Your Ref: Y/5/17/OUT

Our Ref: PE/ARU/17/11/A

Re: Cinders Nursery and land rear of Cinders Lane, Yapton, BN18 0JJ.

Thank you for your correspondence of 08th February 2017, advising me of an outline application for 51no dwellings with all matters reserved except for access at the above location, for which you seek advice from a crime prevention viewpoint.

Appendix A

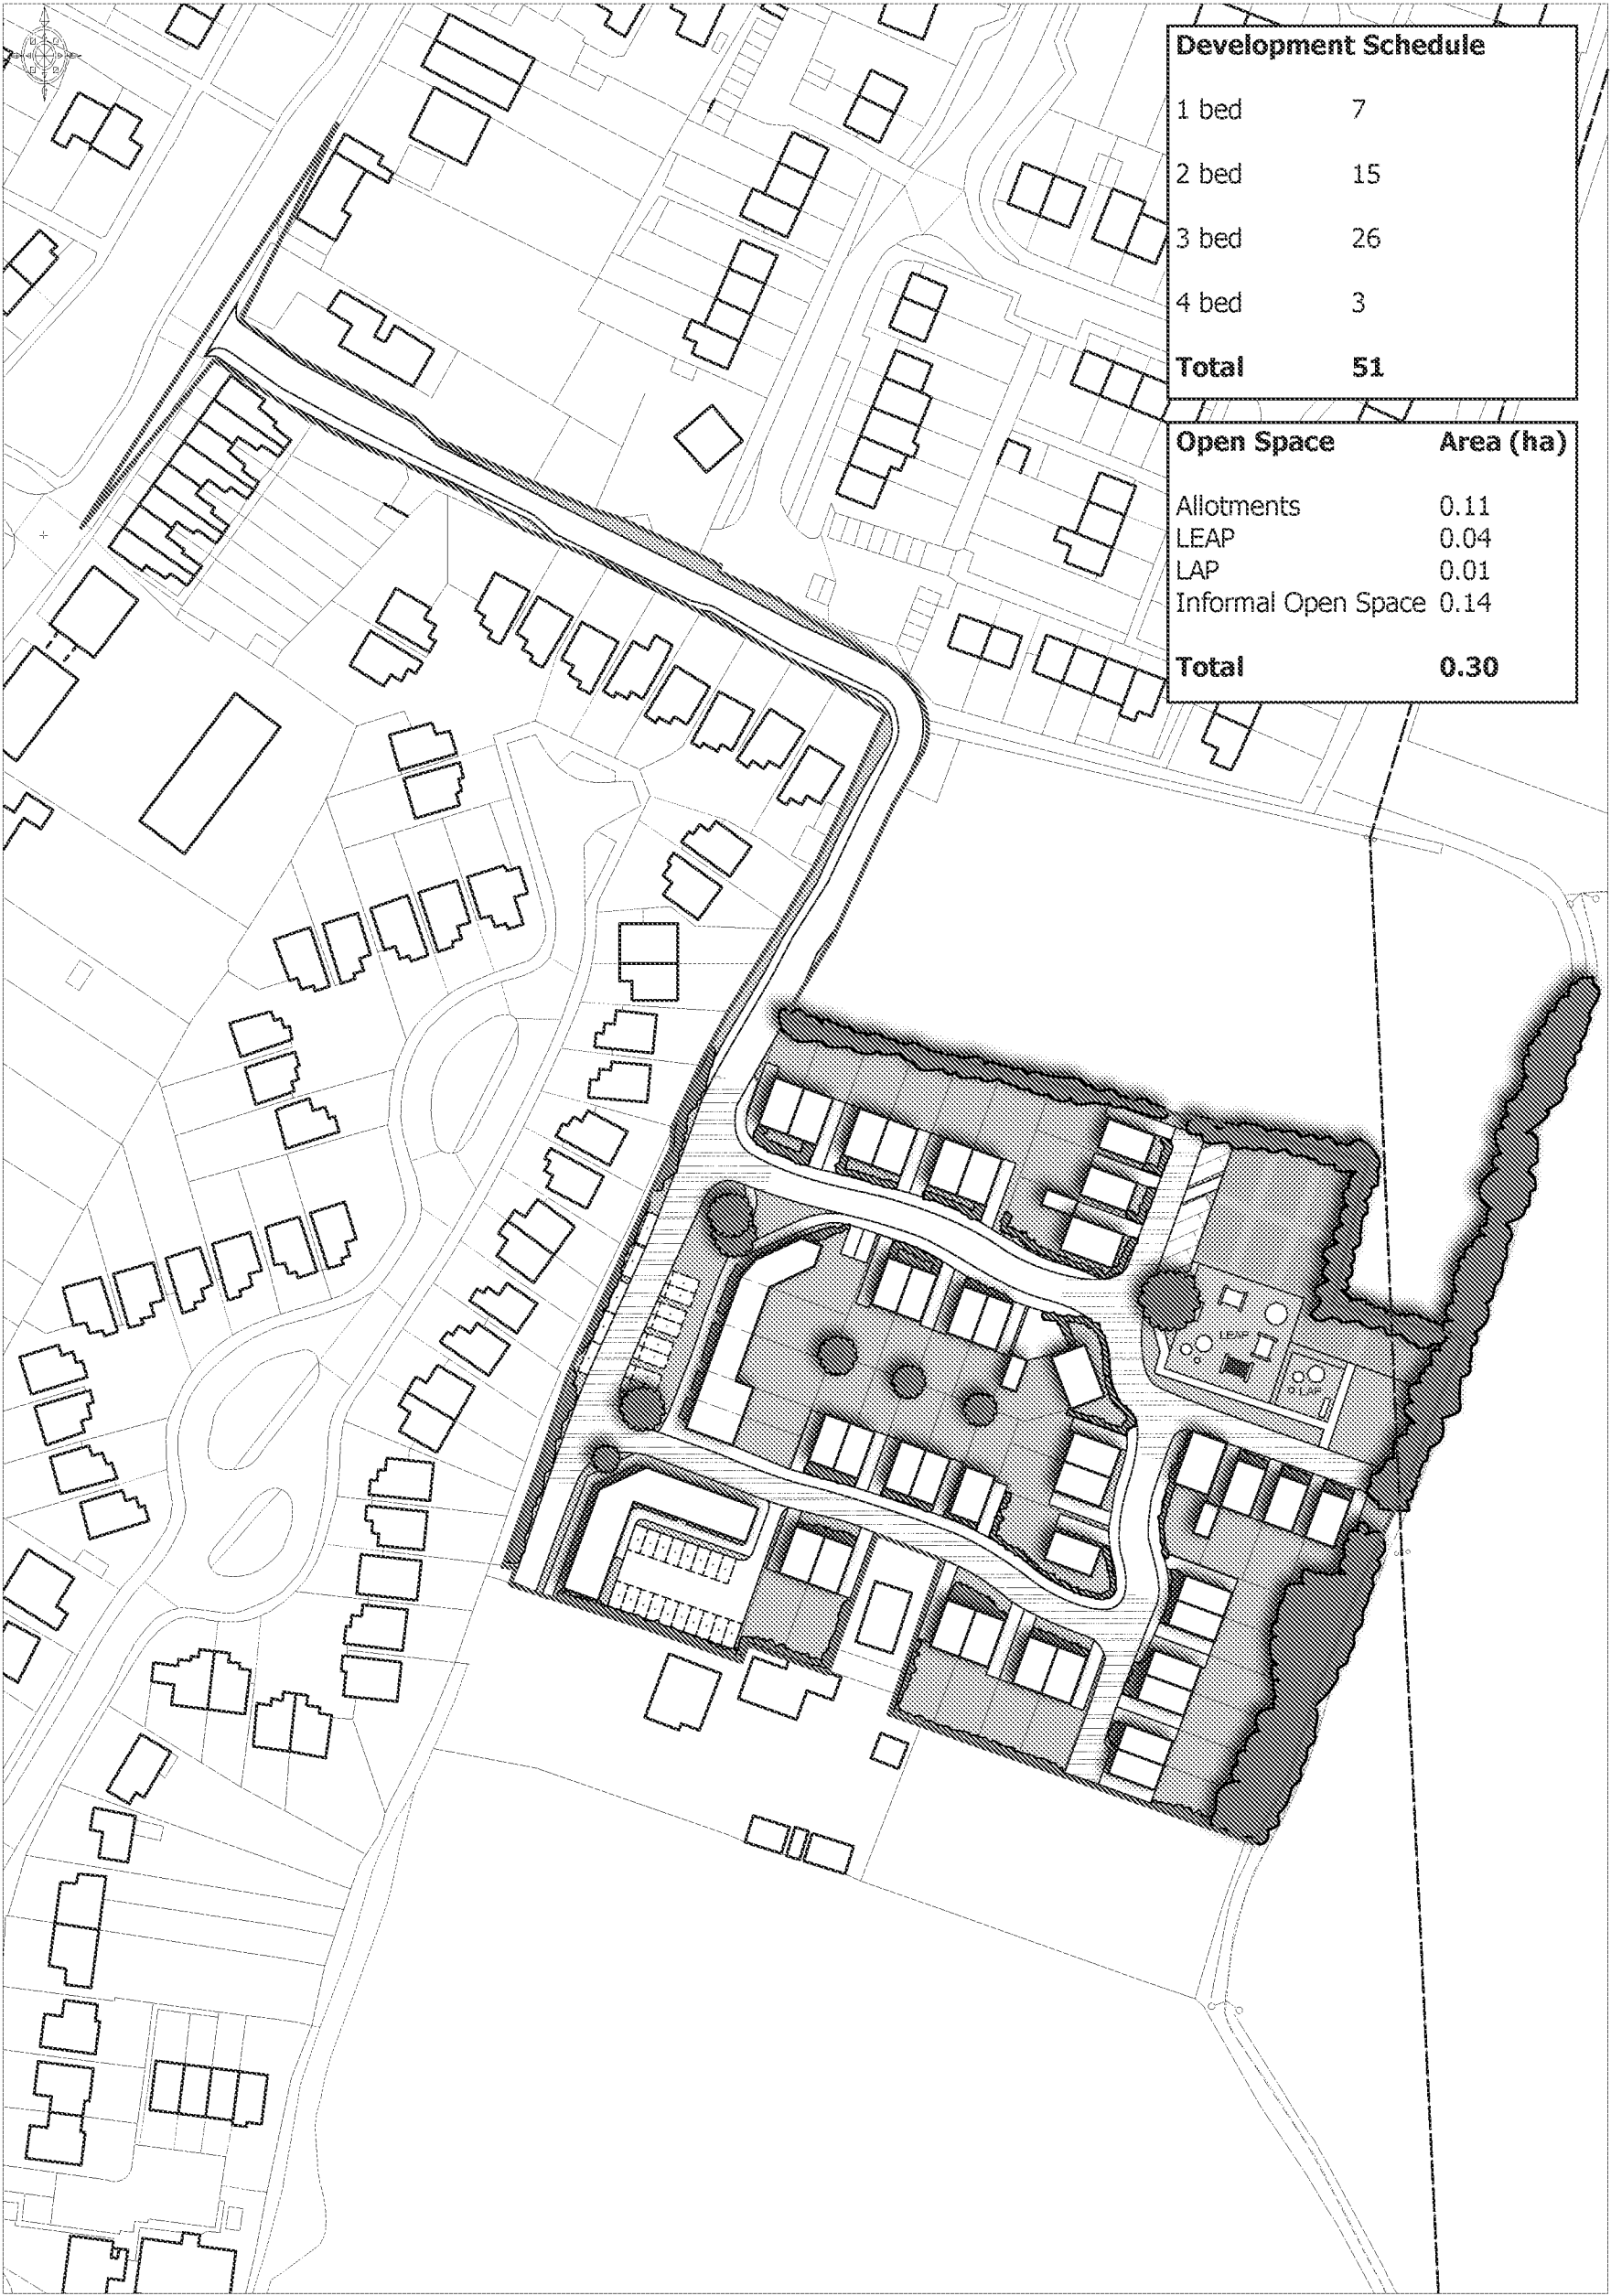
Access to the development at present is via a shared junction and a private track. In order to protect the safety of pedestrians accessing the development I would like to see traffic calming measures implemented along with lighting throughout the development that conforms to the recommendations within BS 5489:2013.

The development in the main has outward facing dwellings with the dwellings having back to back gardens. This has created good active frontage with the streets and the public areas being overlooked, this design has eliminated the need for vulnerable rear garden pathways. Parking in the main has been provided with in-curtilage, garage and a number of on street parking bays, this should leave the street layout free and unobstructed.

As the first line of defence, perimeter fencing must be adequate with vulnerable areas such as side and rear gardens needing more robust defensive barriers by using walls or fencing to a minimum height of 1.8metres. Gates that provide access to the side of the dwelling or rear access to the gardens must be robustly constructed of timber, be the same height as the adjoining fence and be lockable from both sides. Such gates must be located on or as near to the front of the building line as possible.

Where softwood screening and fencing has been installed to the perimeter, in order to deter access it will be imperative to ensure that no hand or footholds have been created that enables easy access over the perimeter fencing.
